WEST SUSSEX COUNTY COUNCIL CONSULTATION

TO:	Arun District Council FAO: Simon Davis
FROM:	WSCC - Highways Authority
DATE:	29 April 2022
LOCATION:	13-17 Richmond Avenue Bognor Regis PO21 2YE
SUBJECT:	BR/48/22/PL Conversion of existing loft space into 2 No flats. This application is in CIL Zone 4 (Zero rated) as flats.
DATE OF SITE VISIT:	n/a
RECOMMENDATION:	Advice
S106 CONTRIBUTION TOTAL:	n/a

DRAWING
LOCATION PLAN
SITE PLAN
DRAWING No
313/101
SCALE
DATE
1:1250 1:500
FEB 2022
DRAWN
CHECKED
LA

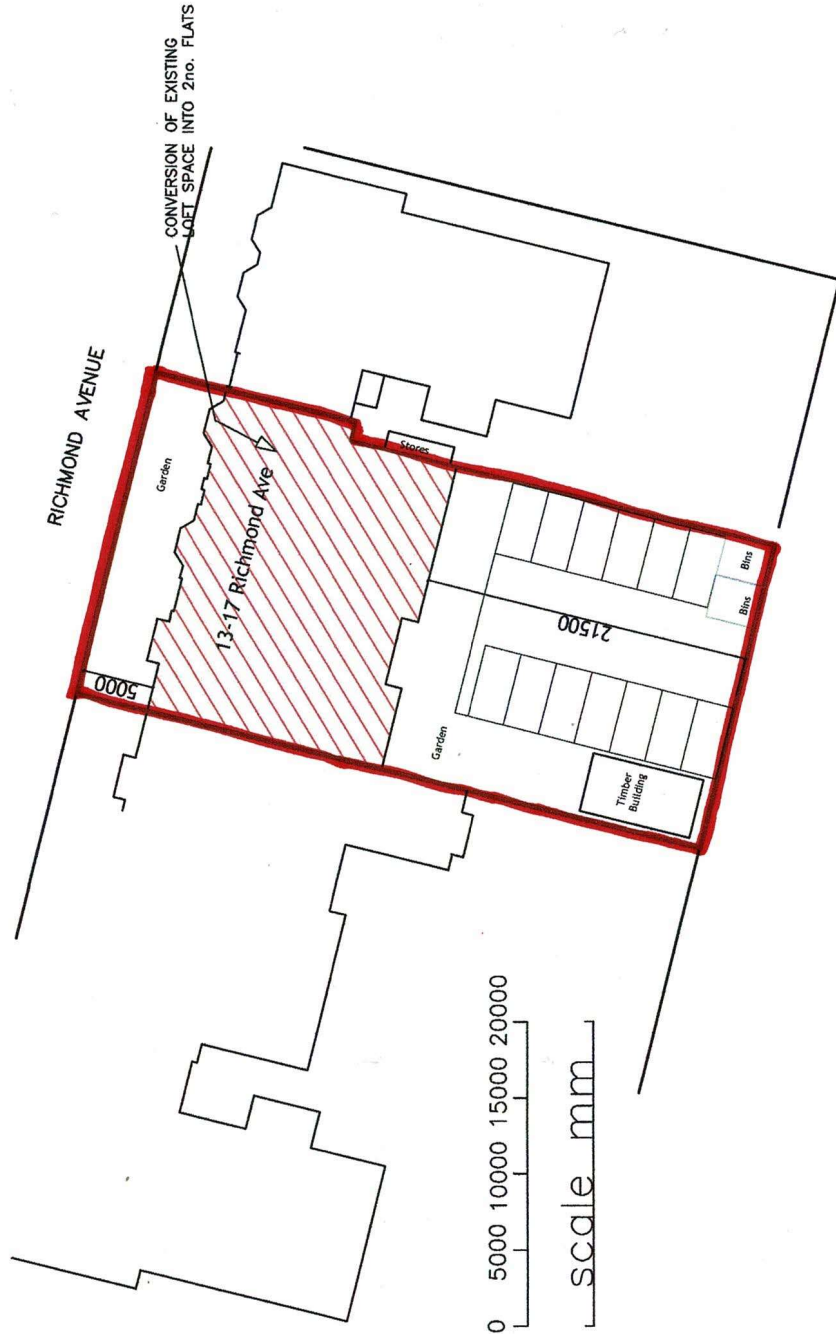
The Design and Access Statement indicates that one additional parking space will be provided within the parking area approved under BR/114/20/PL to serve the new flat - this will result in reconfiguration of the parking area previously approved. The LPA may wish to consider whether a variation of Condition 3 of BR/114/20/PL is required.

A plan demonstrating the floor plans of a secure and covered cycle storage shed to be provided for the flats has been provided, but does not demonstrate the location of the cycle store within the site. Details of this can be secured via condition, and as above, the LPA may wish to consider whether any variation of condition 6 of BR/114/20/PL is required.

No part of the development shall be first occupied until the car parking has been constructed in accordance with the approved site plan. These spaces shall thereafter be retained at all times for their designated purpose.

No part of the development shall be first occupied until covered and secure cycle parking spaces have been provided in accordance with plans and details to be submitted to and approved by the Local Planning Authority.
